Arun District Council
Arun Civic Centre
Maltravers Road
Littlehampton
West Sussex BN17 5LF
Planning & Building Control General Enquiries
Tel: (01903) 737756 Fax: (01903) 730442
Dx: 57406 Littlehampton
Minicom: 01903 732765
e-mail: planning@arun.gov.uk
website: www.arun.gov.uk/planning

Application No: BR/129/21/OUT
Site Address: 26 Burnham Avenue Bognor Regis PO21 2JU
Description of works: Outline application with all matters reserved for up to 10 No. new dwellings with associated services, landscaping, car parking & amenity (resubmission following BR/190/20/OUT).

Thank you for your internet representation made on 9th June 2021 which has been recorded as an objection with the comments as follows:

SITE PLAN (PROPOSED) 1:200

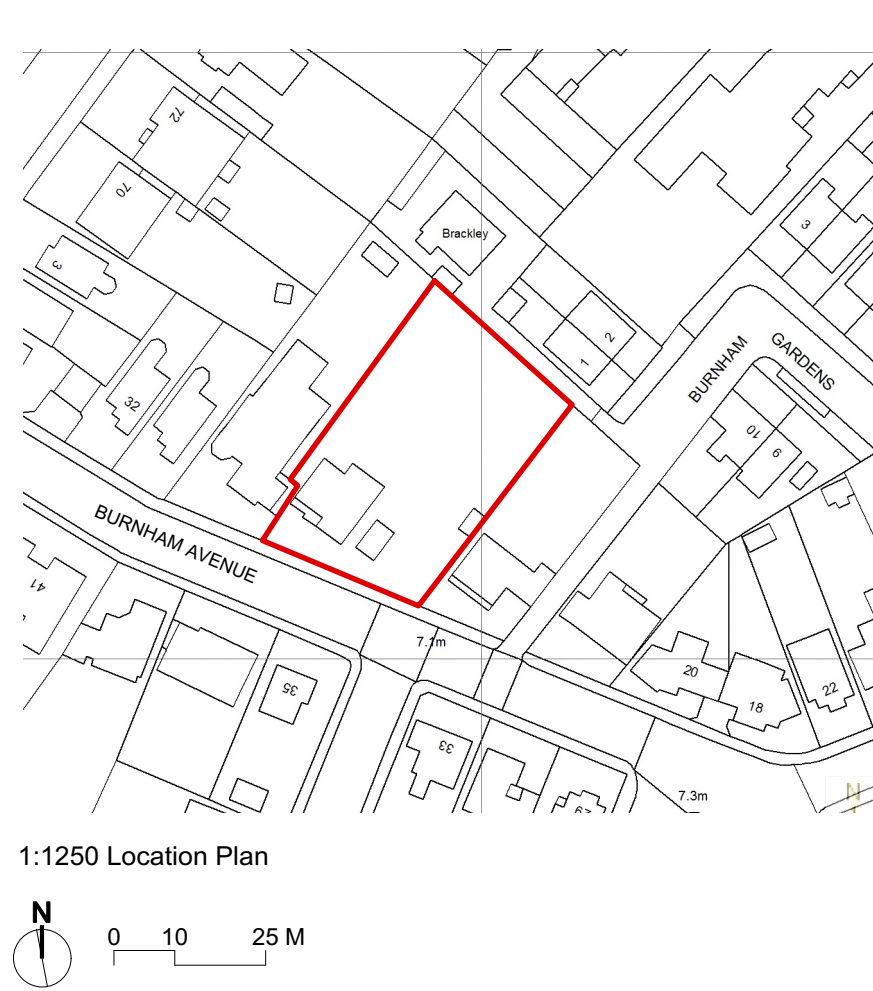
Policy D SP1 of the Arun Local Plan 2011-2031 stipulates that the design should reflect the characteristics of the site and local area. Members were of the opinion that these proposals do not meet this criteria and show a lack of sensitive understanding of the site/context and does not respond to locally distinctive patterns of development. The scale of the proposed development detracts from the local and wider area's character and is not within the general confines of the overall character. The proposed dwellings would, by virtue of its layout, siting and size, result in an overdevelopment of the site and have an overbearing impact on the neighbouring properties.

Members are concerned that this proposal will have a significant impact on the road network. The plans fail to demonstrate that this development will not impact on existing capacity of public highways to accommodate parking and is, therefore, contrary to Policy 8b of the Bognor Regis Neighbourhood Development Plan 2015-2030.
